Approval of reserved matters following outline consent WA/26/18/OUT for layout & scale for 6 No. dwellings & 6 No. detached garages.

Lanes End West Walberton Lane Walberton

Thank you for your internet representation made on 8th December 2019 which has been recorded as '**an objection**' with the comments as follows:

PJ DEVELOPMENTS LTD 2 Square Chambers 23 High Street Emsworth PO10 7AQ Tel: 0843 289 3430 Email: enquiries@pjdevelopmentsltd.com	
PROJECT: FORMER LANES END	
SITE PLAN OUTLINE PLANNING APPLICATION	
DATE: JANUARY 2019	DWG. NO 19-001 PL02
SCALE @ A1: 1:200	
REV: C

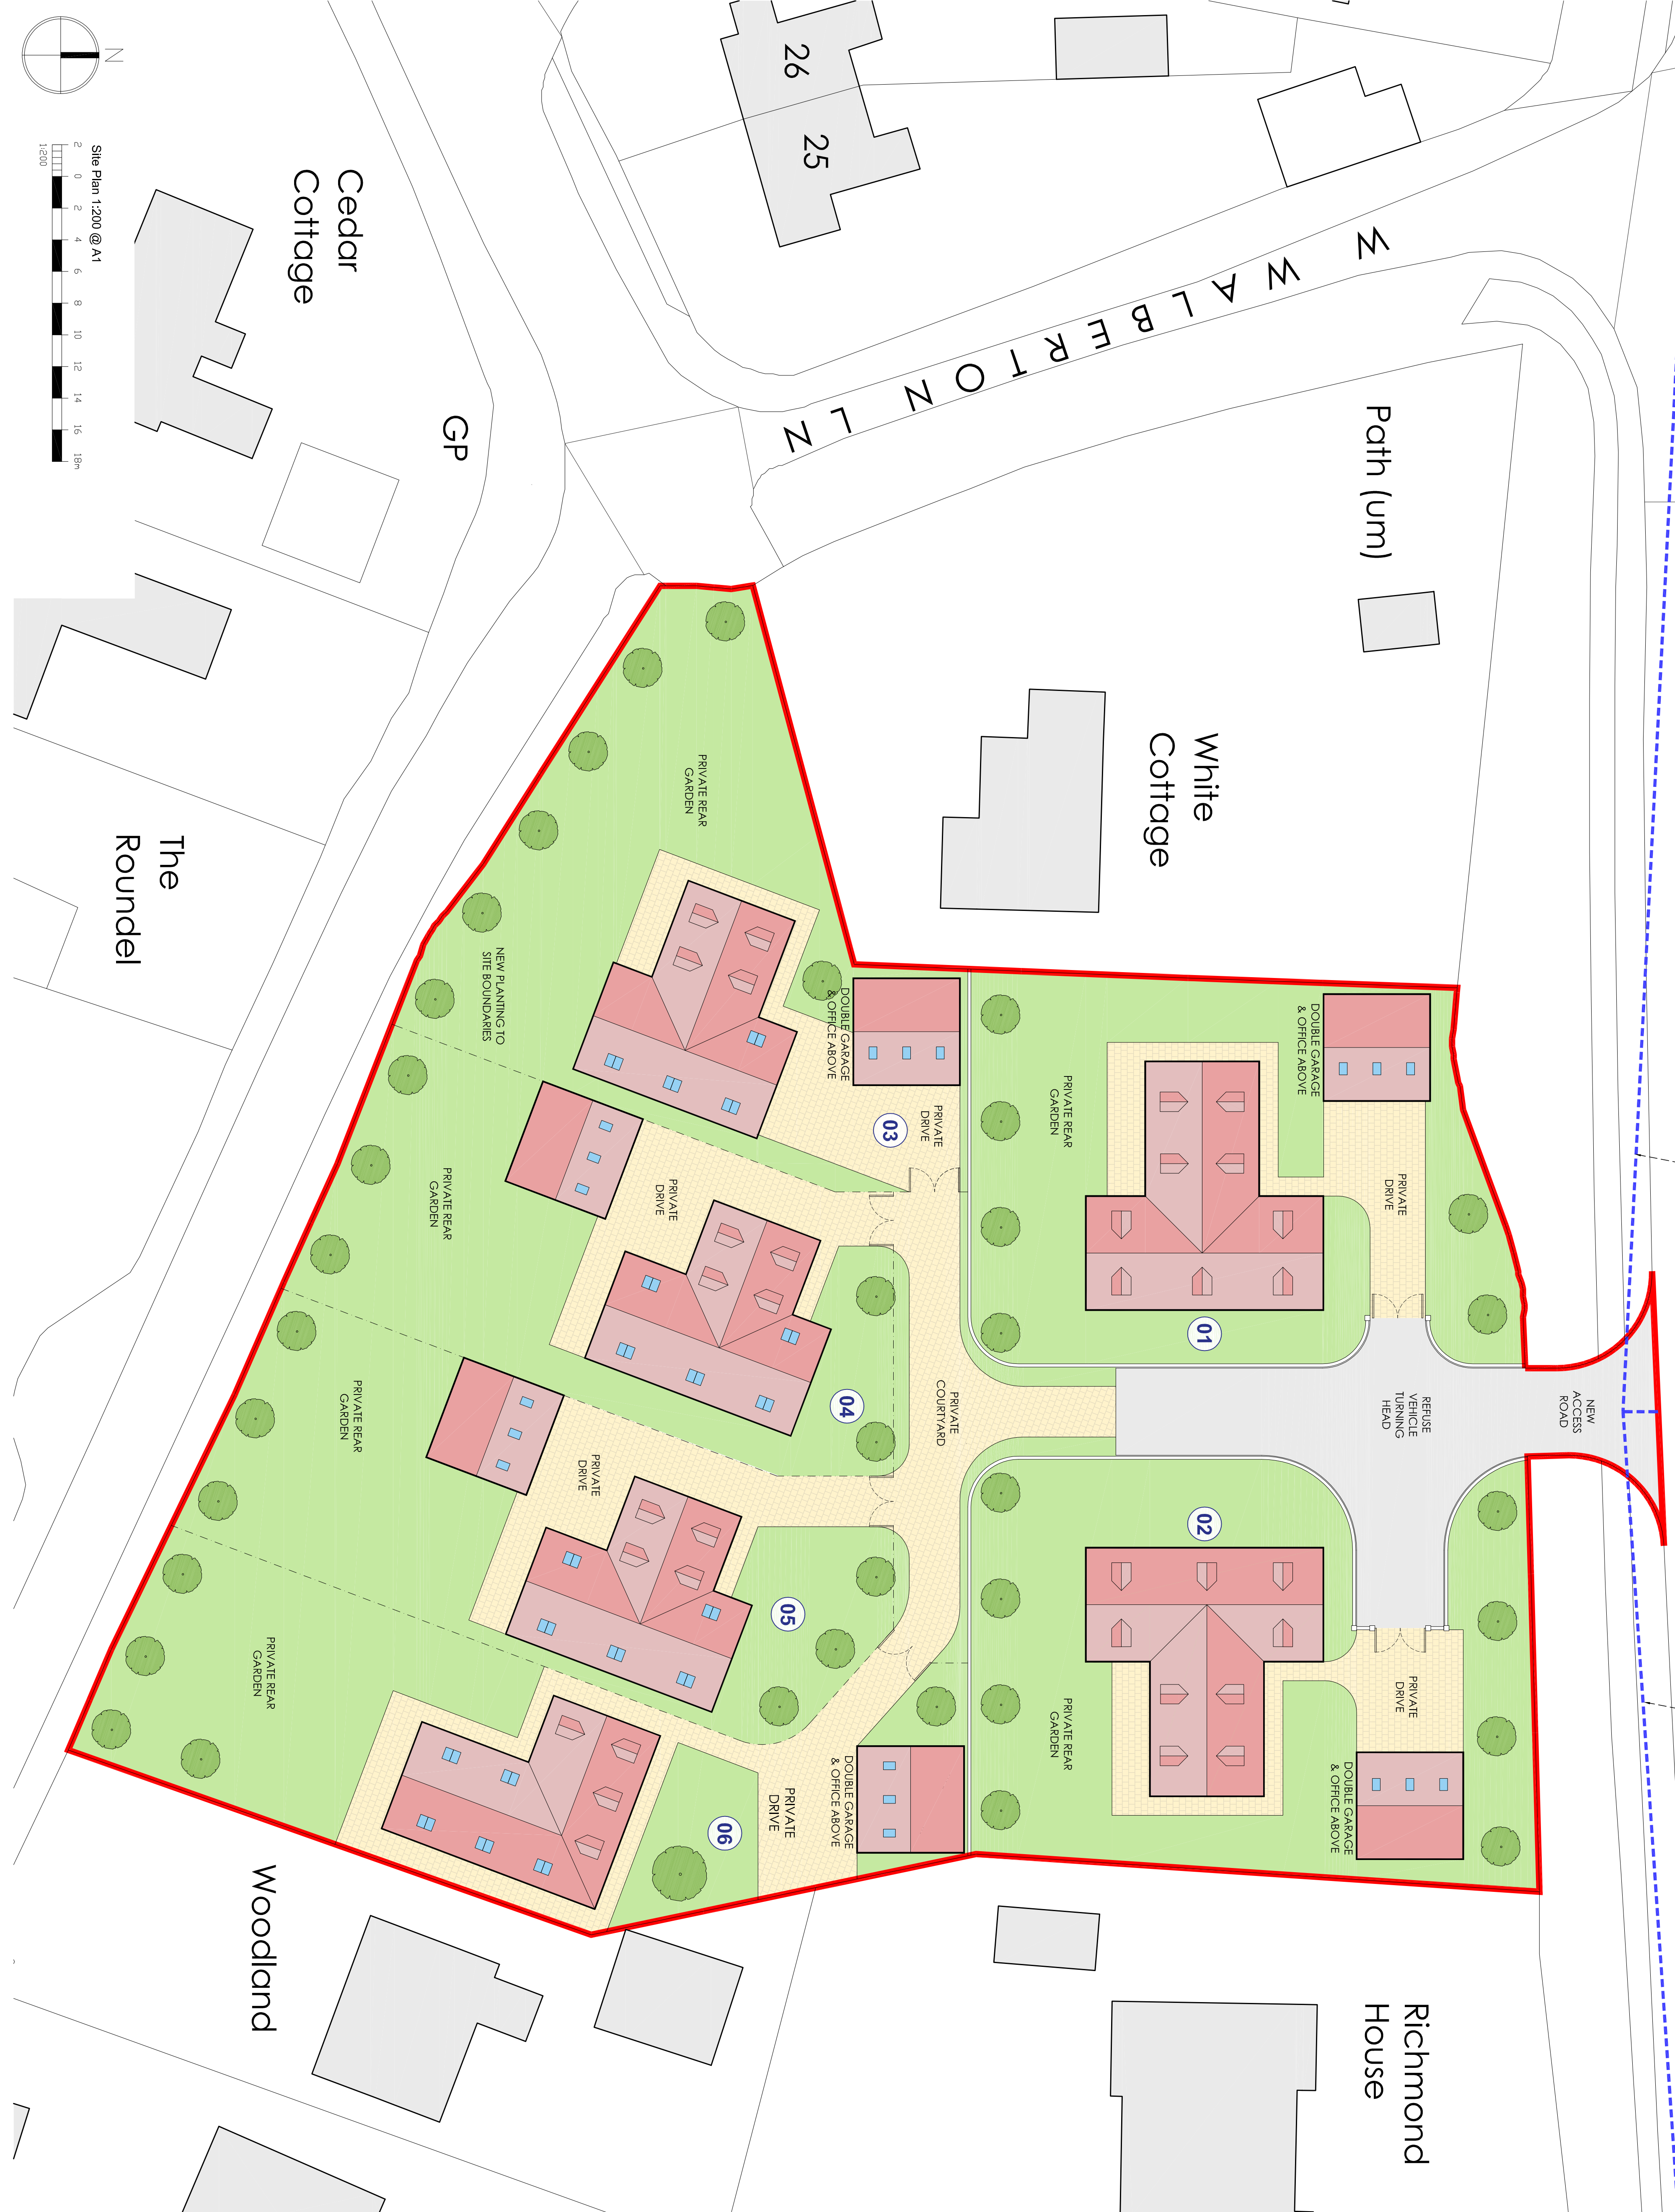
The unit nearest to the existing property Woodland will be far to close, causing a significant reduction in privacy and light. It is out of keeping with all the current surrounding properties.

The effect on the trees and wildlife in this development area will be significant and still does not seem to be being adequately addressed.
